From: [REDACTED]
Sent: 22 March 2019 15:20
To: Charlotte Easton
Cc: debi williams
Subject: Re: R7/19/CLP - 9 Hawke Close, Rustington

From: [REDACTED]
Sent: 20 March 2019 14:09
To: Charlotte Easton
Cc: debi williams
Subject: R7/19/CLP - 9 Hawke Close, Rustington

PROPOSED ELEVATIONS

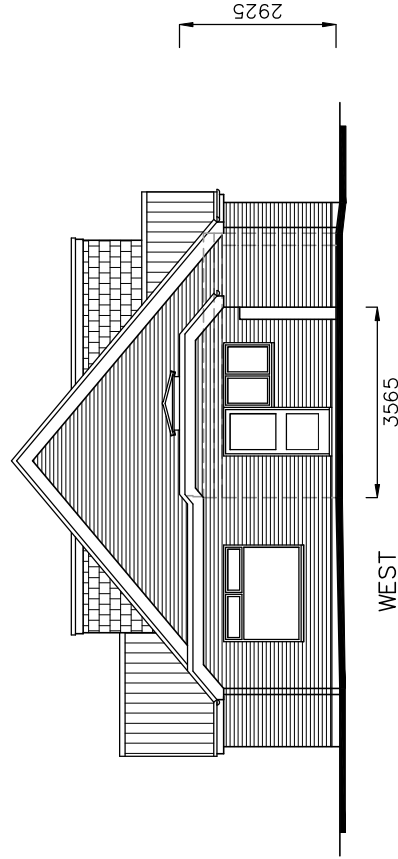
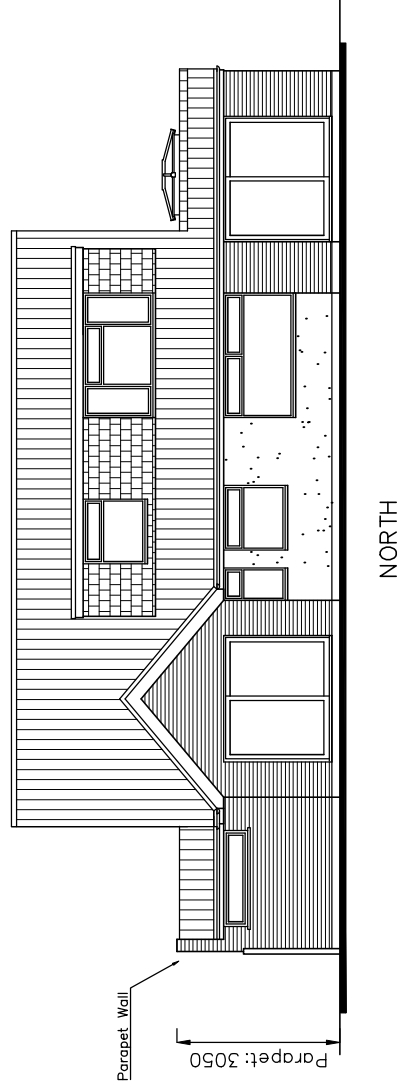
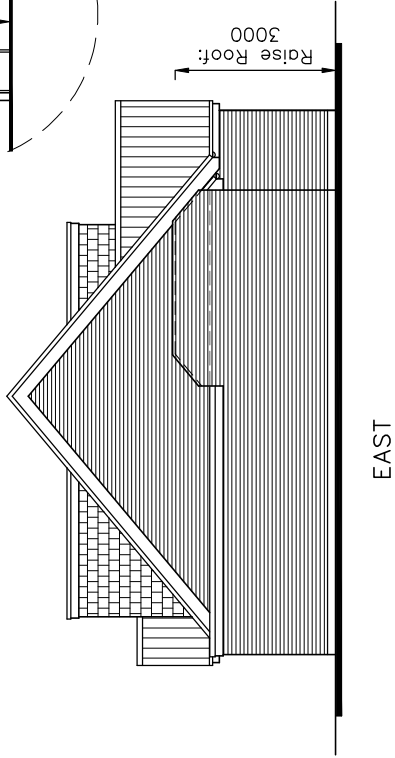
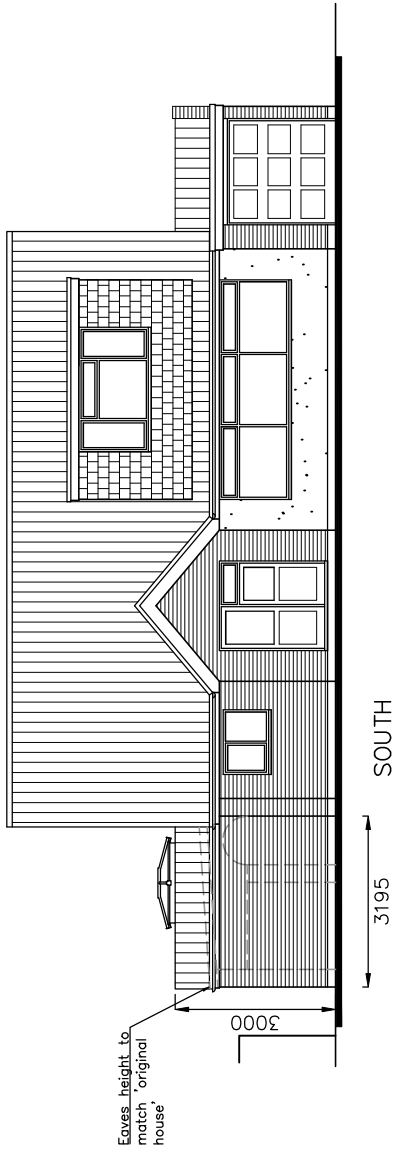
Yes the drawings attached are the ones I have been measuring from, the rear extension measures at 4.1 metres in height.

At present my report would state that permission would be required for the rear extension part of the submission. The plans submitted show the rear extension to be a height of 4.1m which obviously is above the permitted development height of 4m.

Could you confirm if you wish to revise the drawing or for me to issue the current response.

The rear half of the existing garage is proposed to have a raised roof height of 3m.

The proposed side extension is proposed to have a roof height of 2.925m.

There is no proposed rear extension.

We are therefore unsure what measurement you are referring to. Please confirm.
